PORTLAND MAINE

January 31, 2011,

Re: 11 Allison Street – 353 A014 – R-2 – deck

BUILDING SKETCH

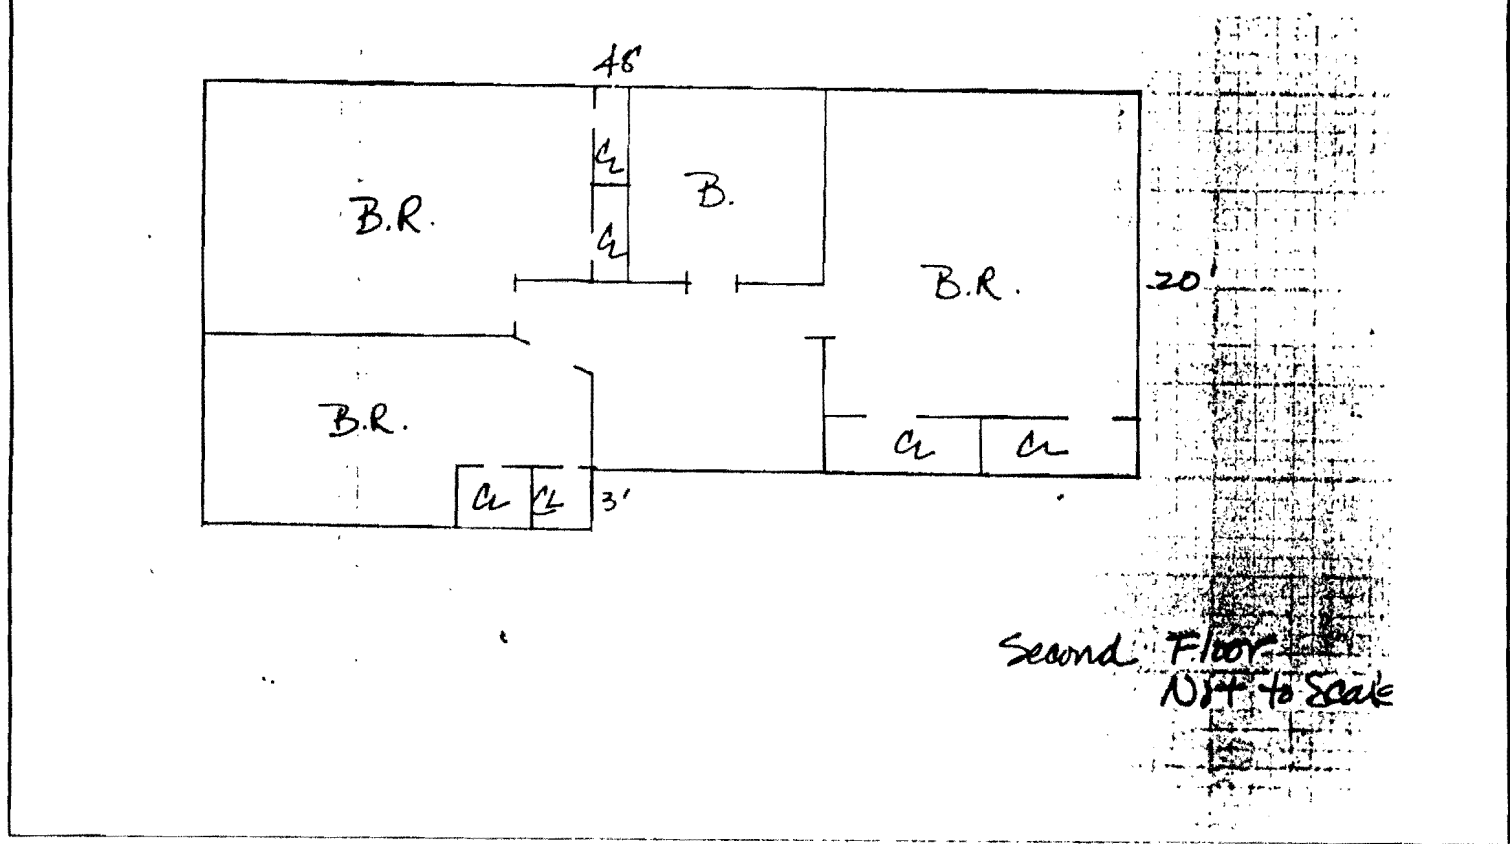
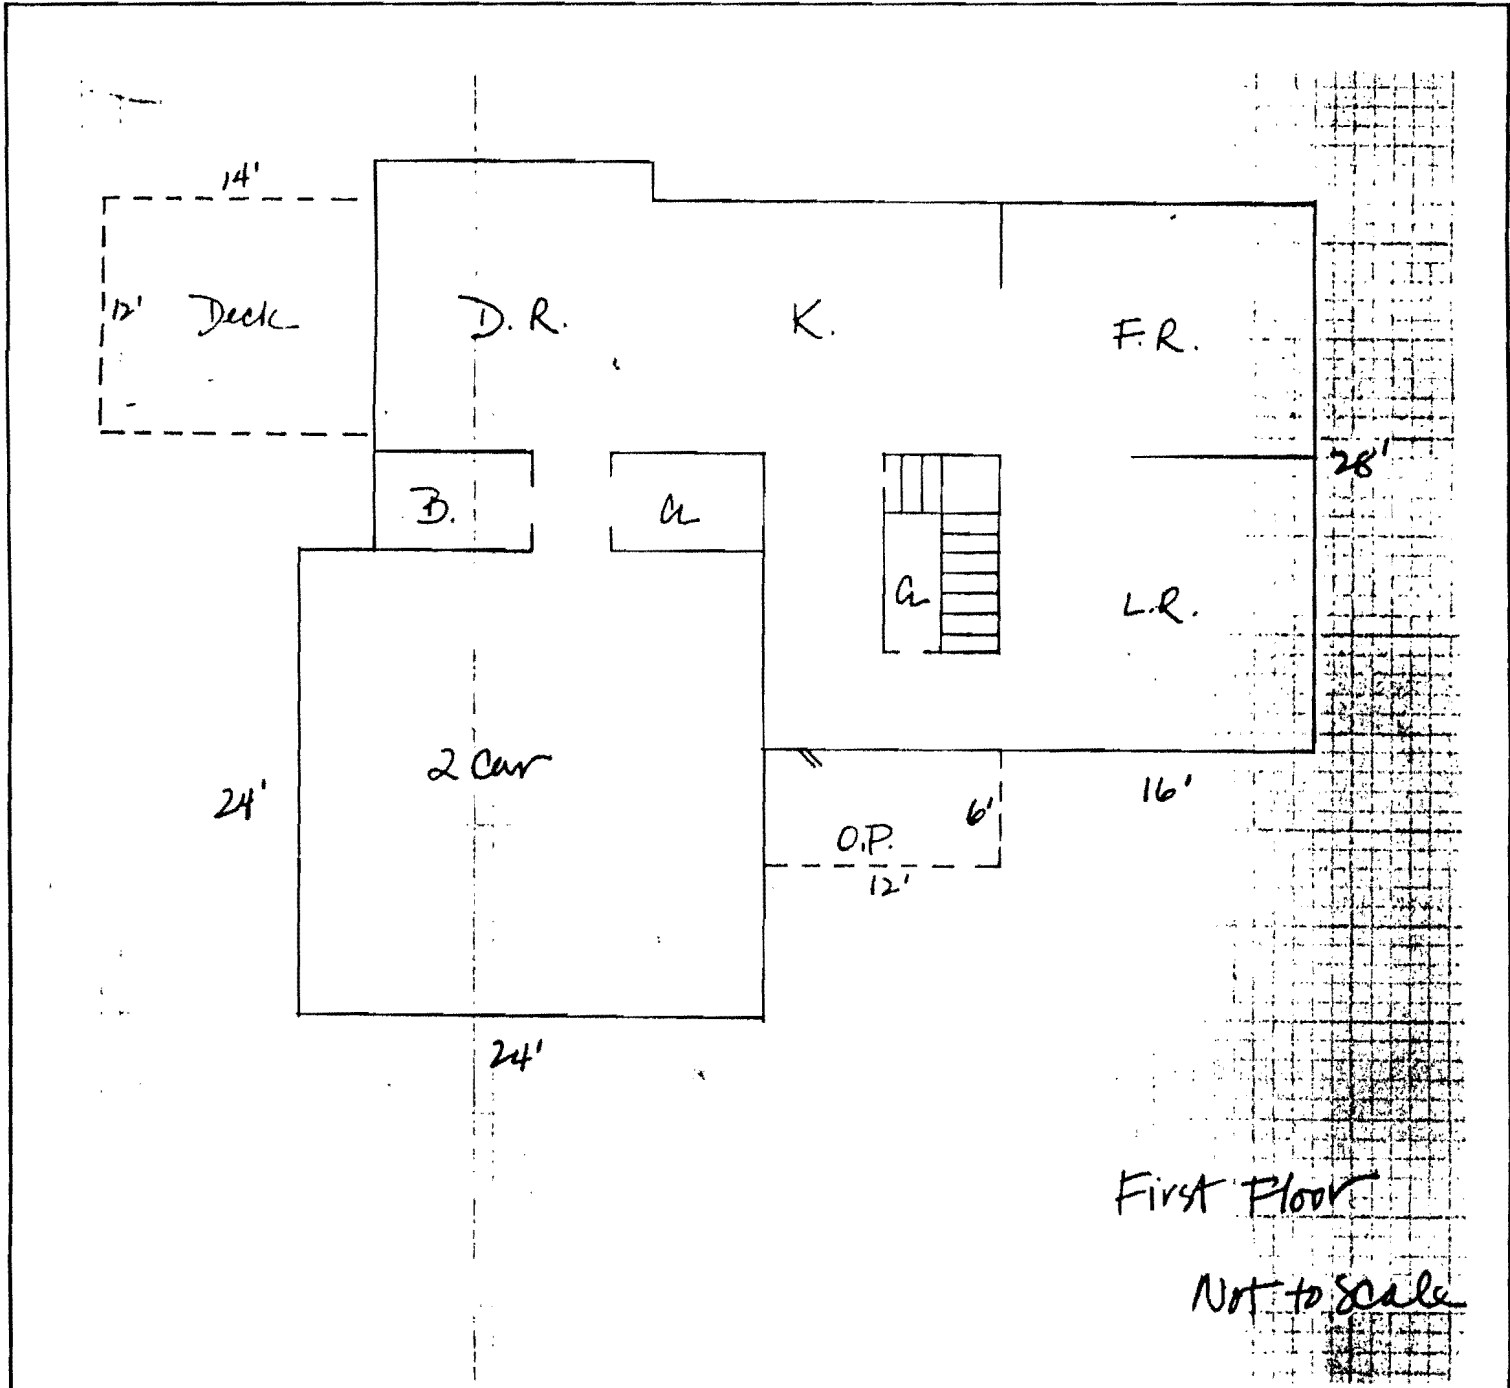
I have reviewed your application to add a second bathroom to the second floor of your house at 11 Allison Avenue. Since the proposal meets the zoning requirements, I have signed off for zoning and moved the permit forward in the review process. In my review though, I saw that the floor plan for the first floor showed a 14' x 12' deck coming off the rear of the house. This deck was not shown on the plot plan. I did some research and could not find a building permit for the deck. If the deck was not permitted, it is not legal.

You need to bring your property into compliance. You need to apply for a building permit to permit the deck after the fact or you need to remove it. You have thirty days to bring your property into compliance.
